320190763P

Feazer Cottage

Re: Documentation to support application for variation/removal of conditions relating to application number 3/2019/0217

Conditions to be varied or removed:

Drawing no 6008/a

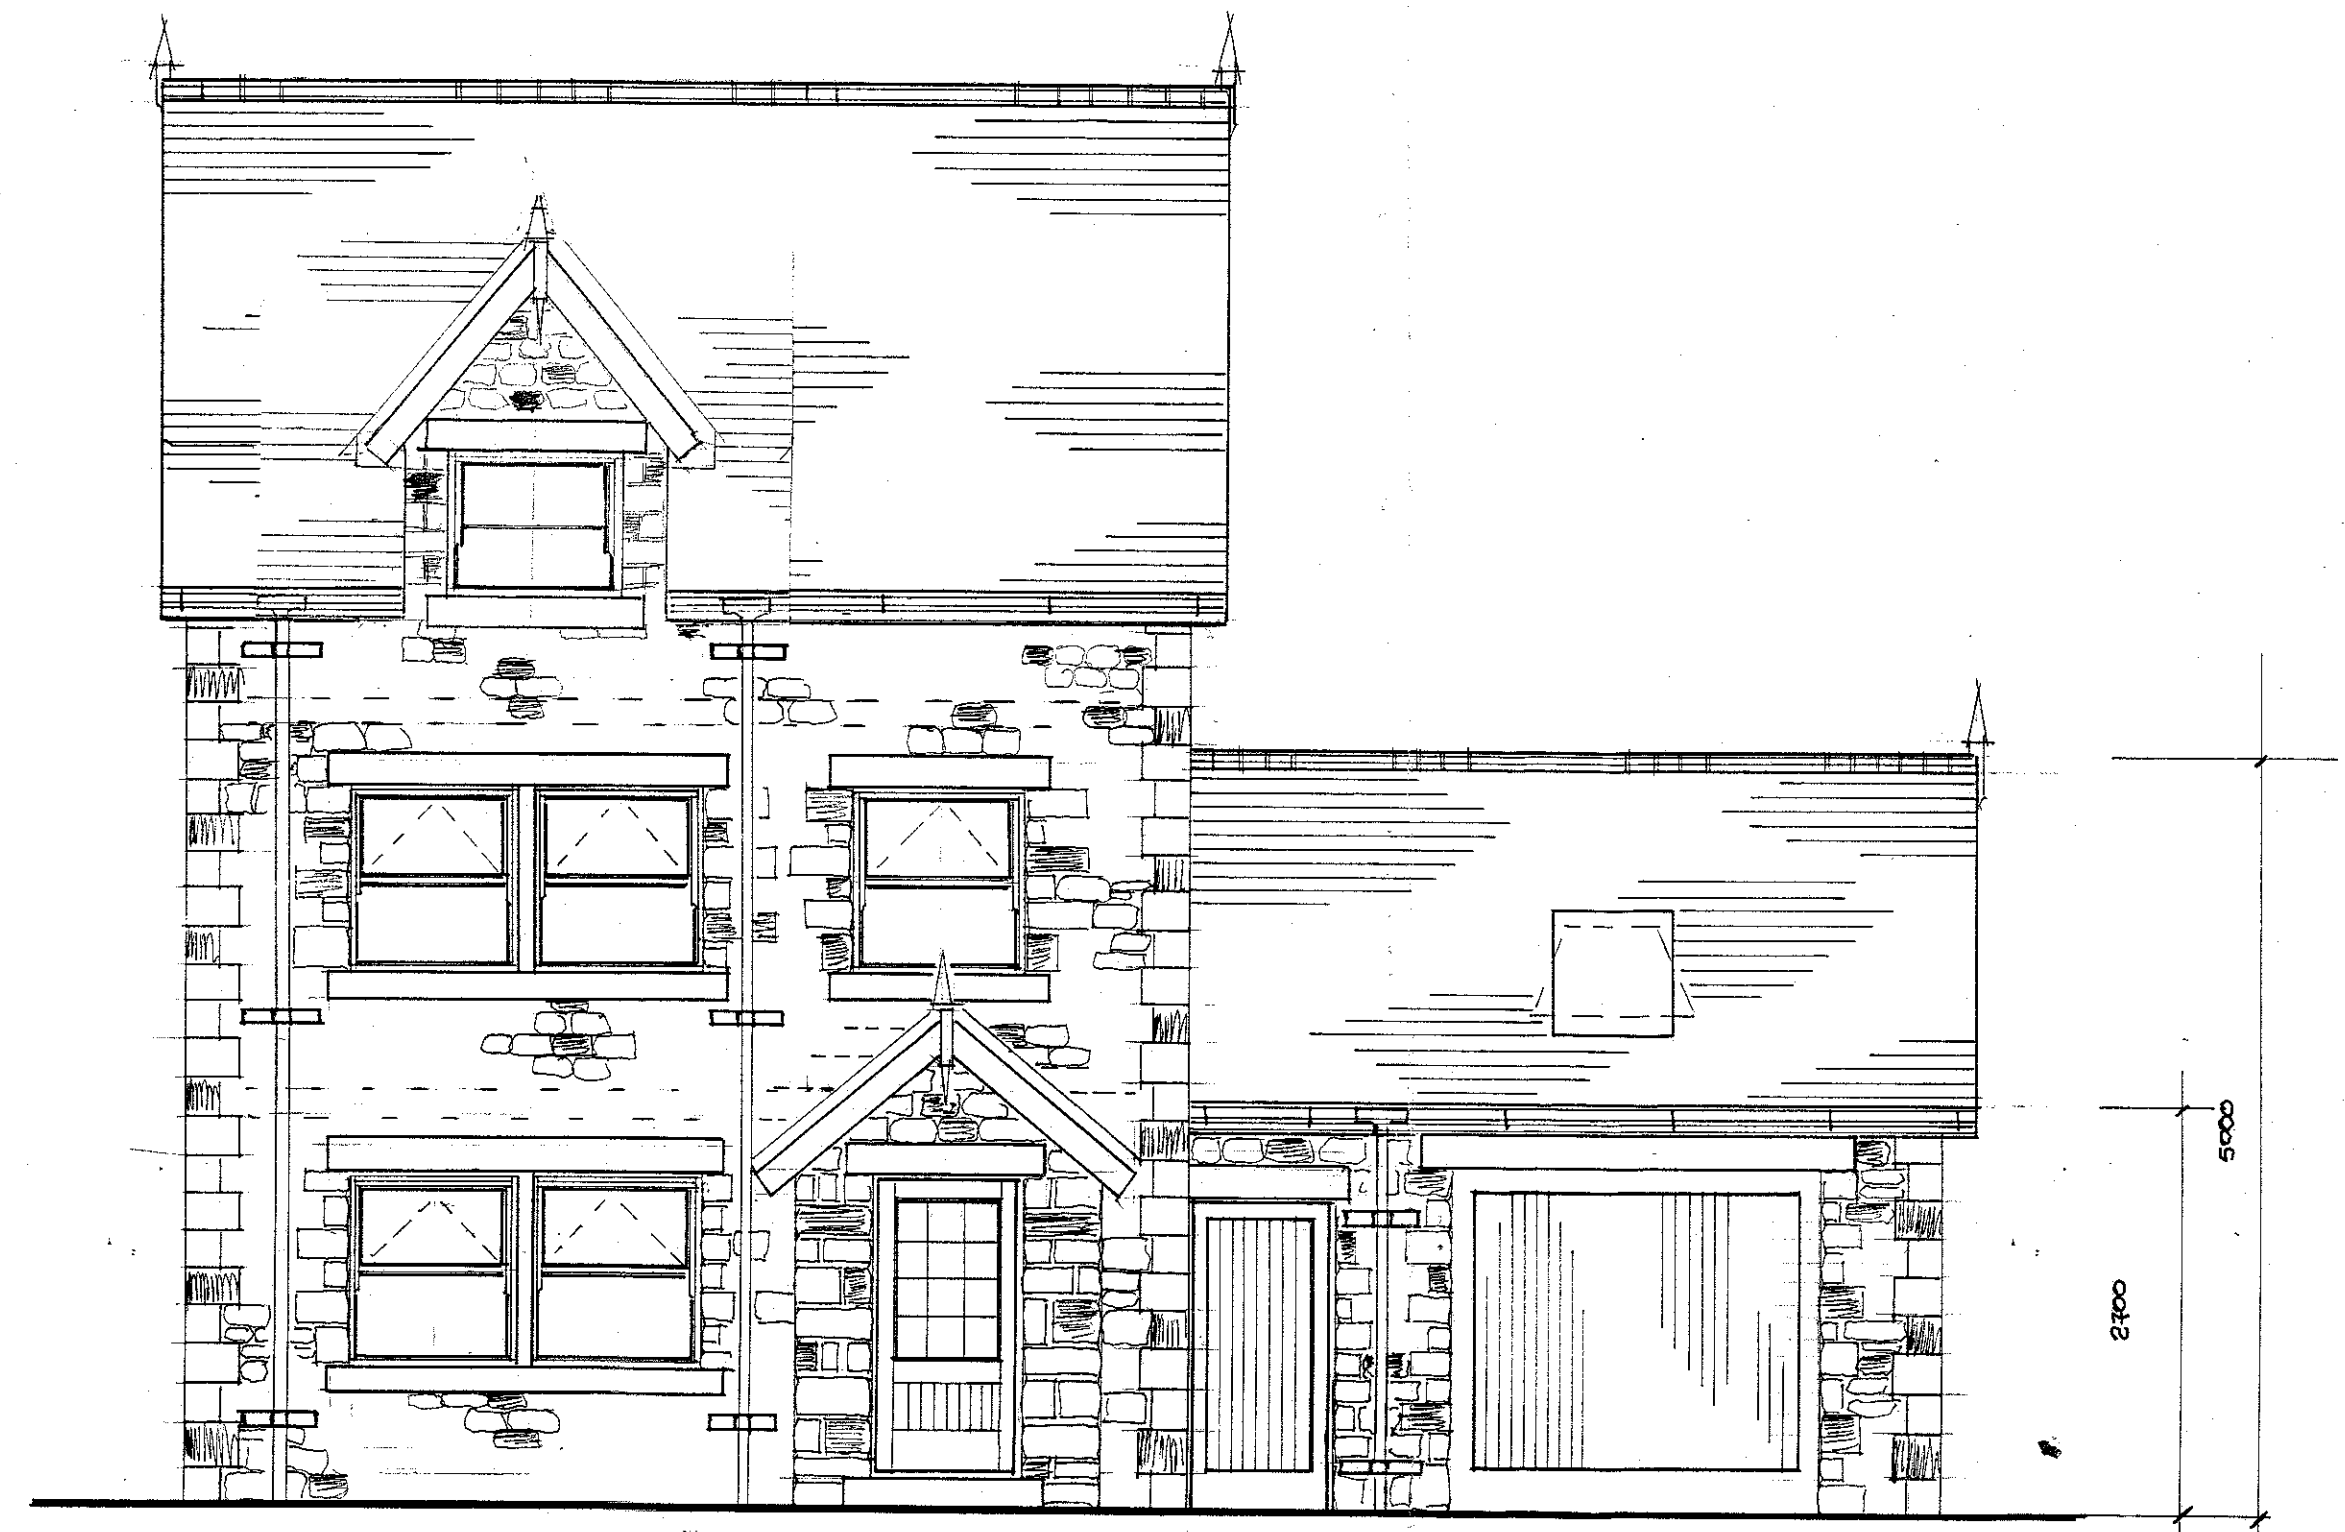
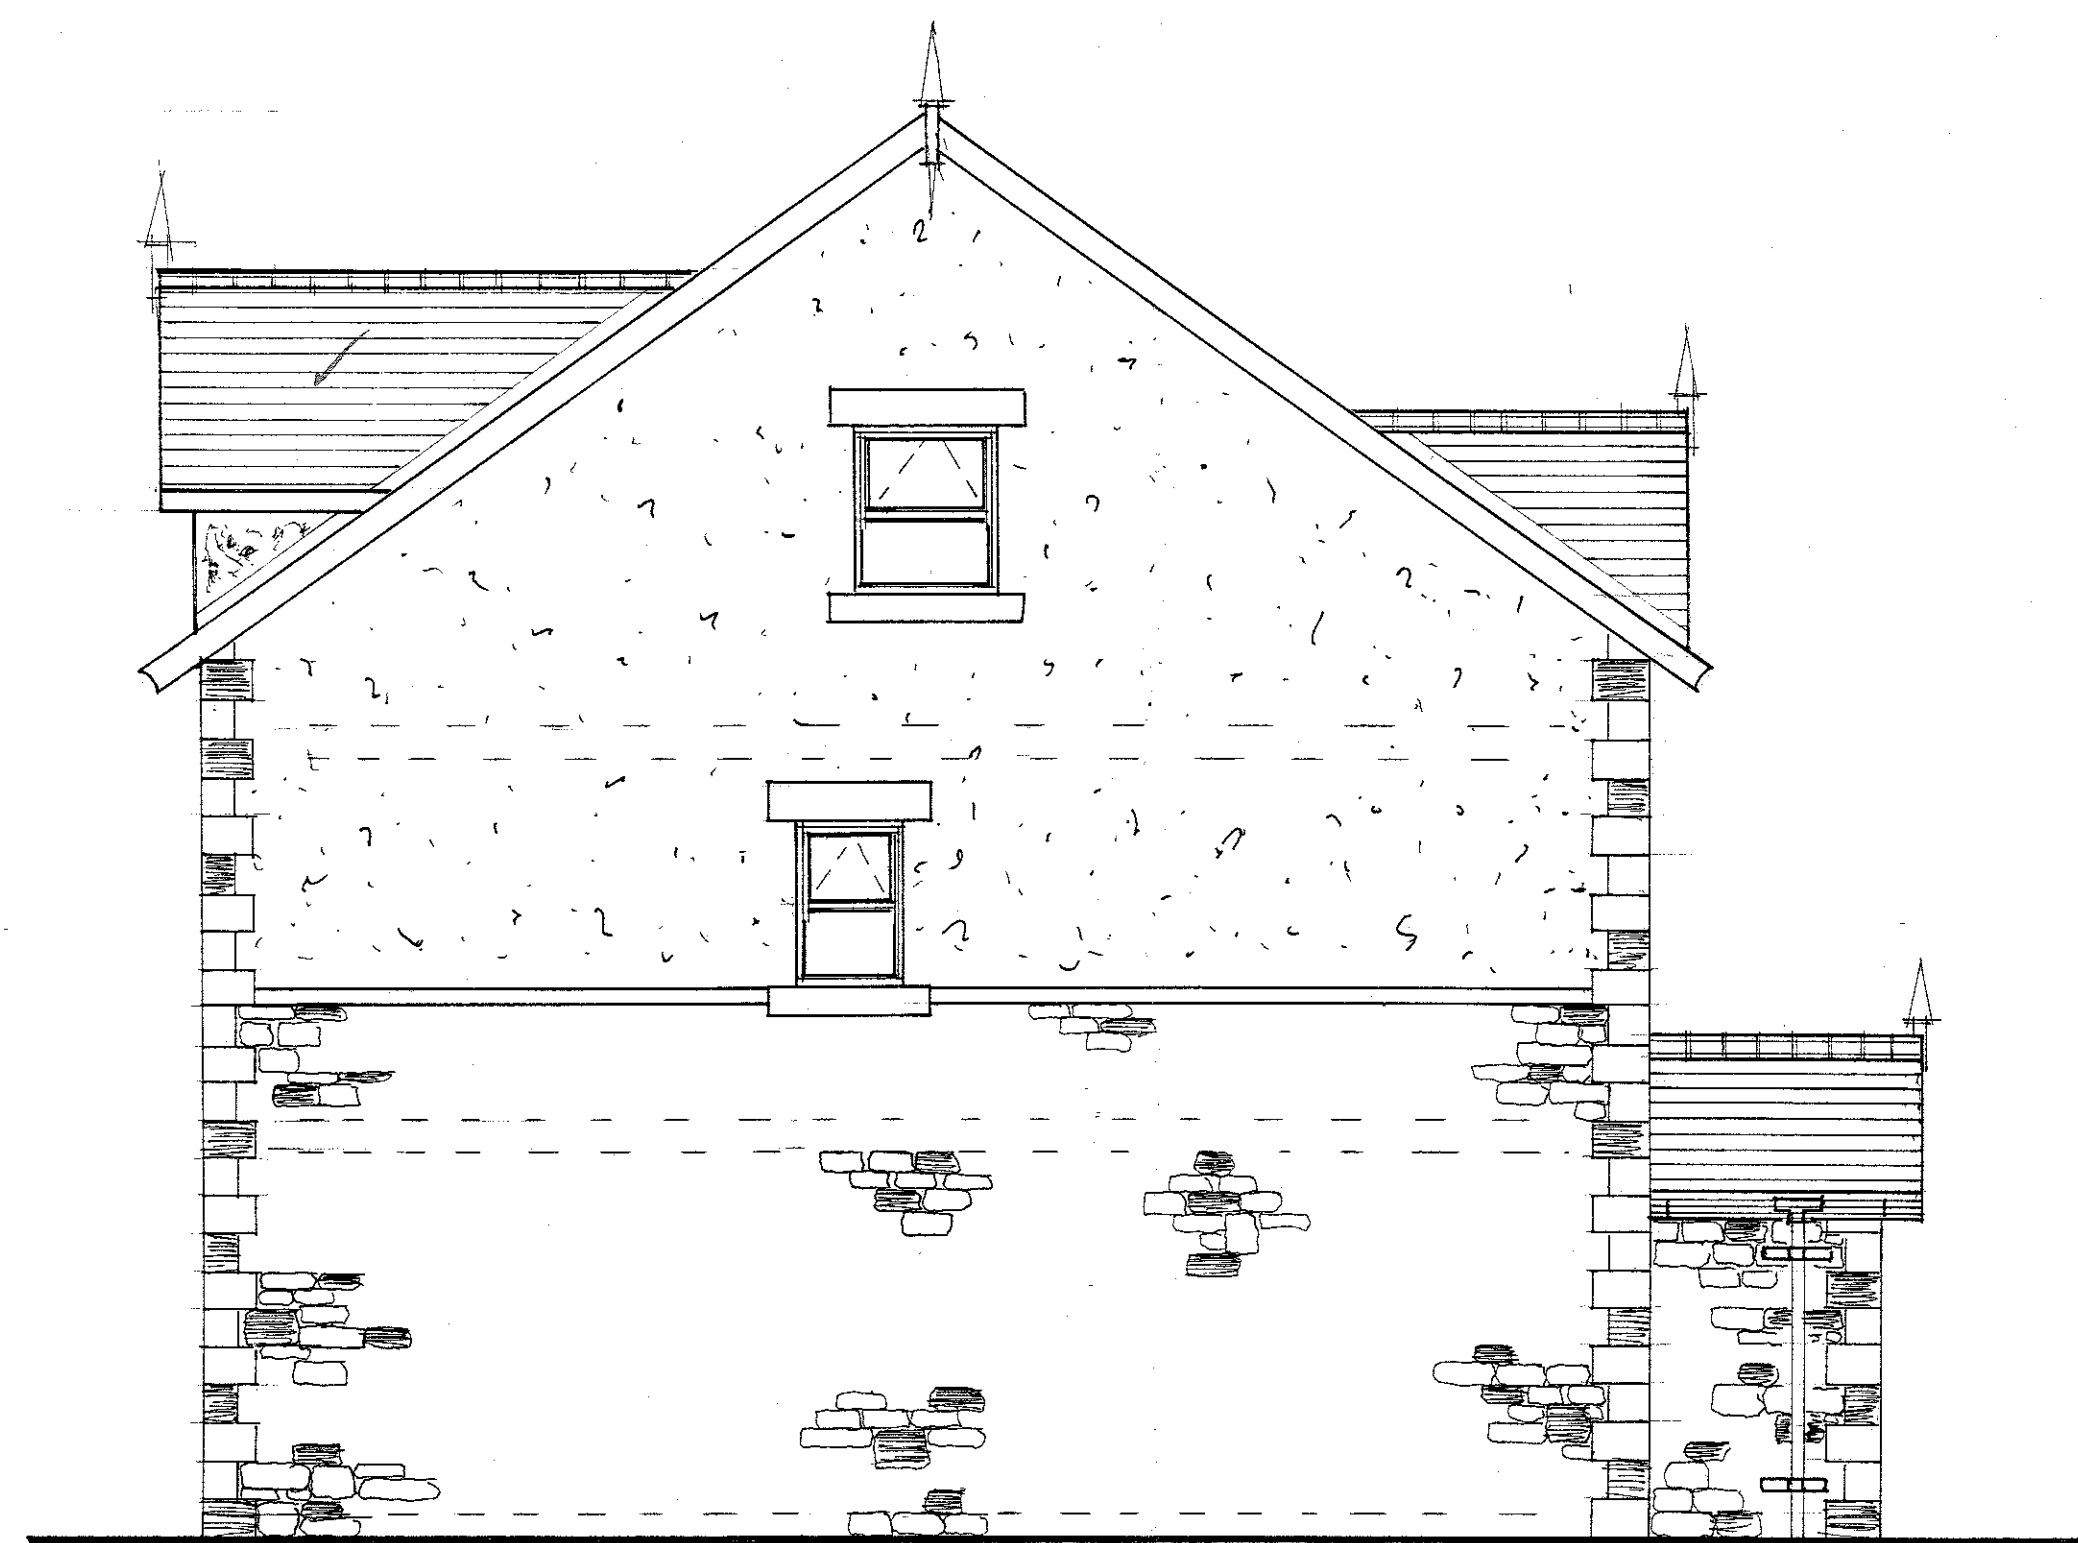
Along with additions of gablets to Plot C roof due to the raised elevations and long distant views from the property. (Photos 001, 002, 003 & support document)

6008 Plot C Elevation (Additional Gablets)

6008a New Plot C Elevation (Showing external position of new gablets)

S.J. Bialecki Limited Building Surveyors
Drawing no 6007/a
Scale 1:50
Plot C Floor Layouts
Proposed Residential Development On Land At Ribblesdale View Chatburn

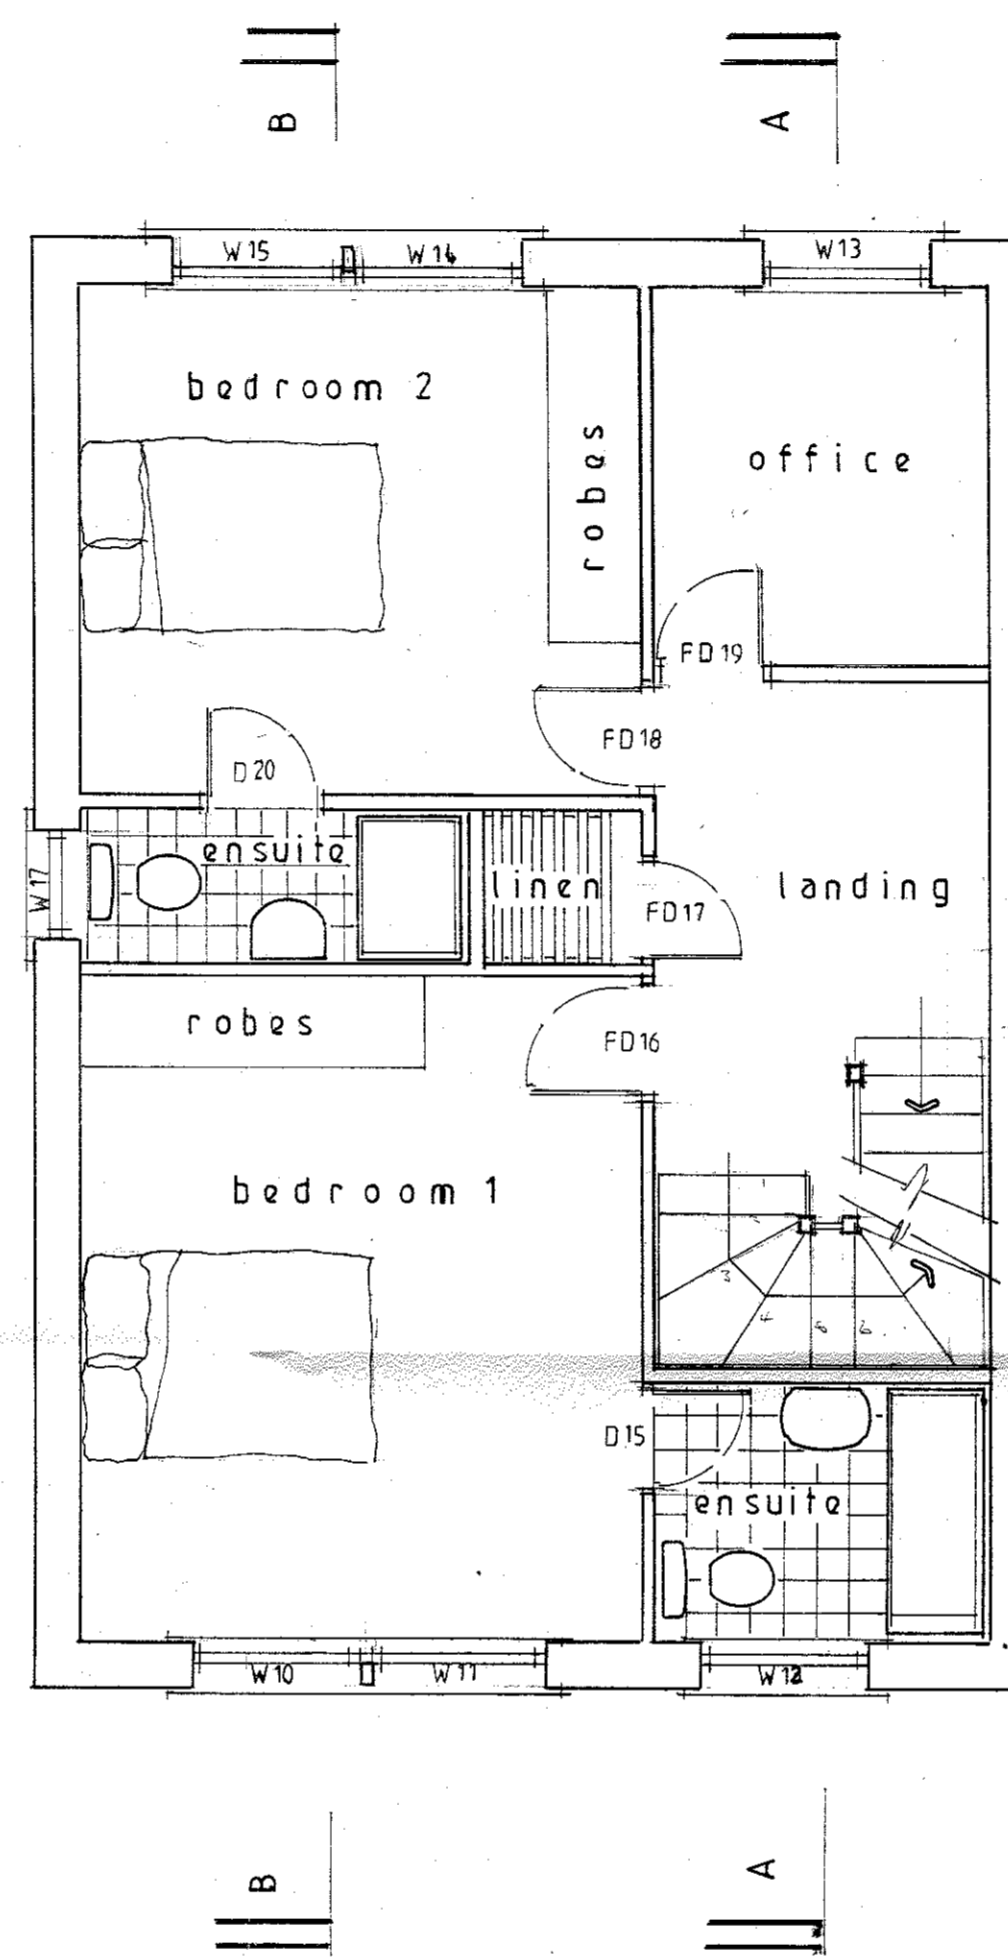
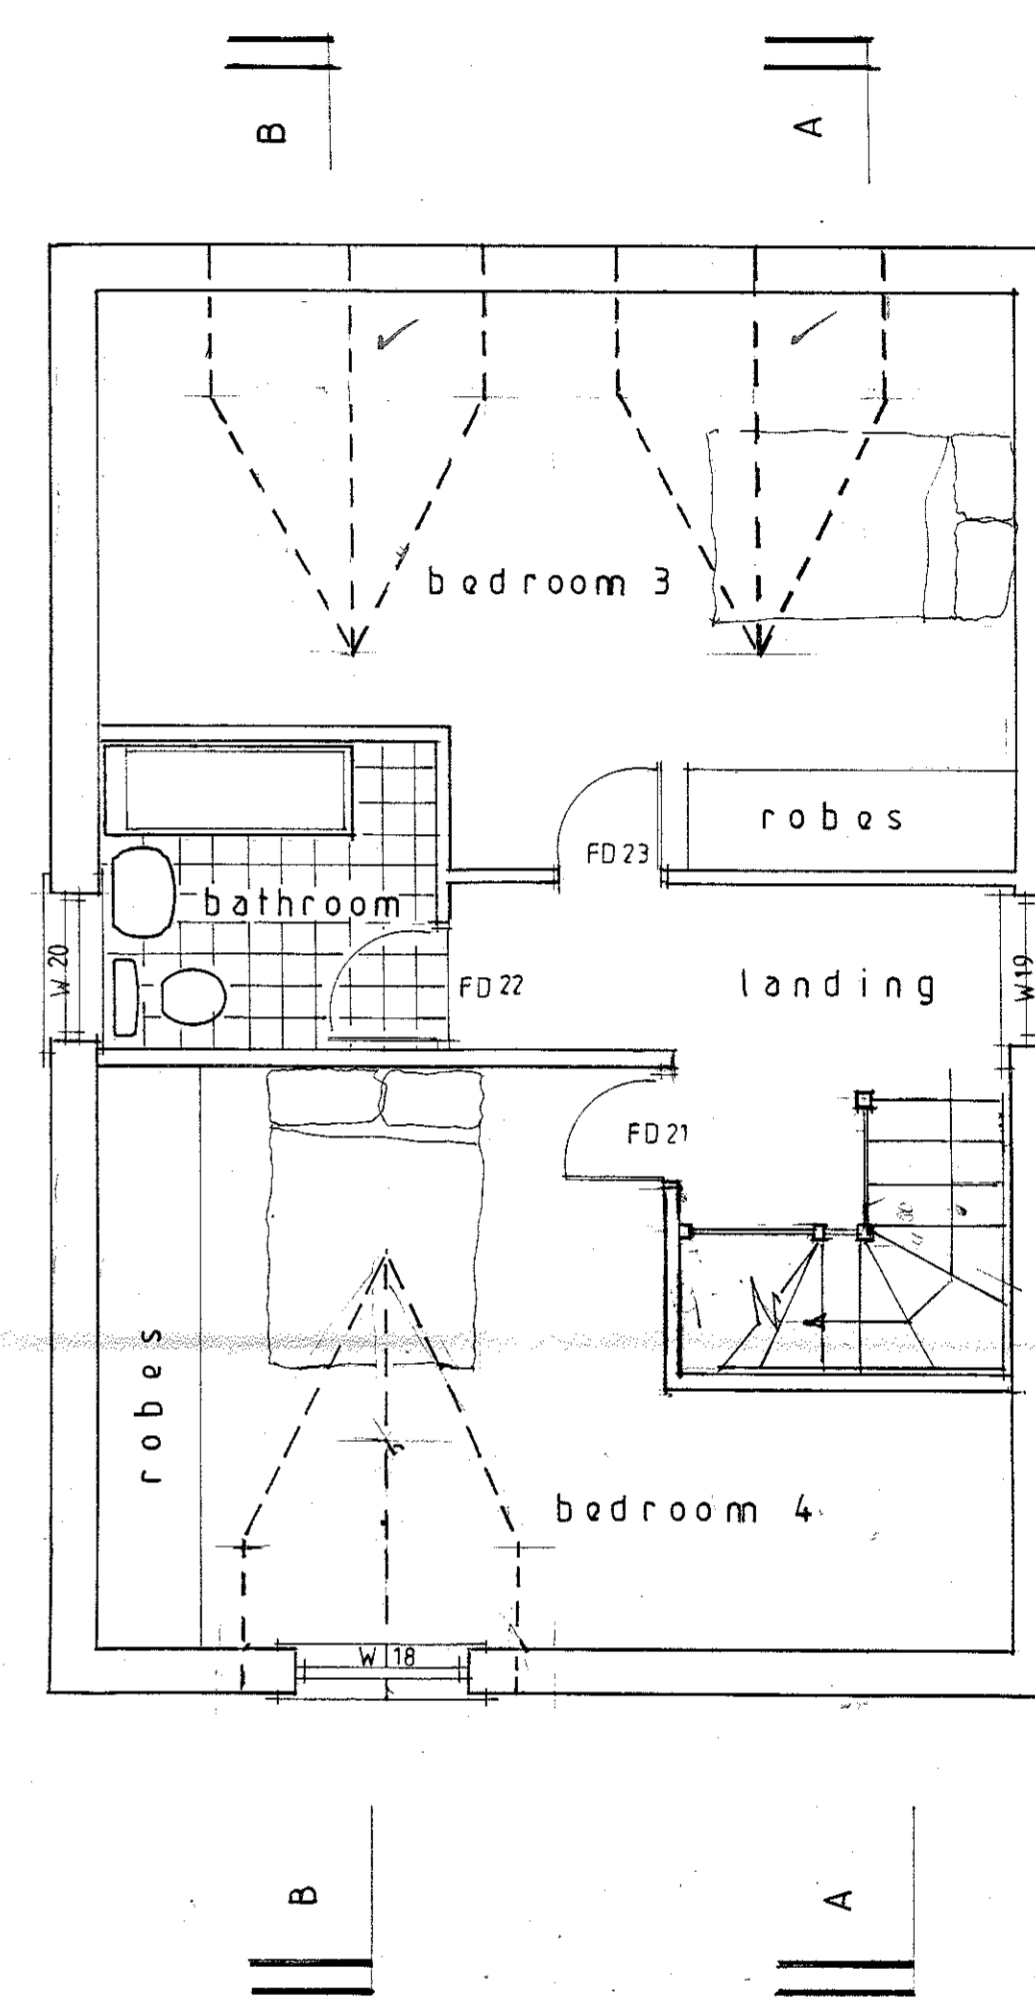
6007 Plot C Floor Layout (Additional Gablets)

6007a New Plot C Floor Layout (Showing internal positions of new gablets)
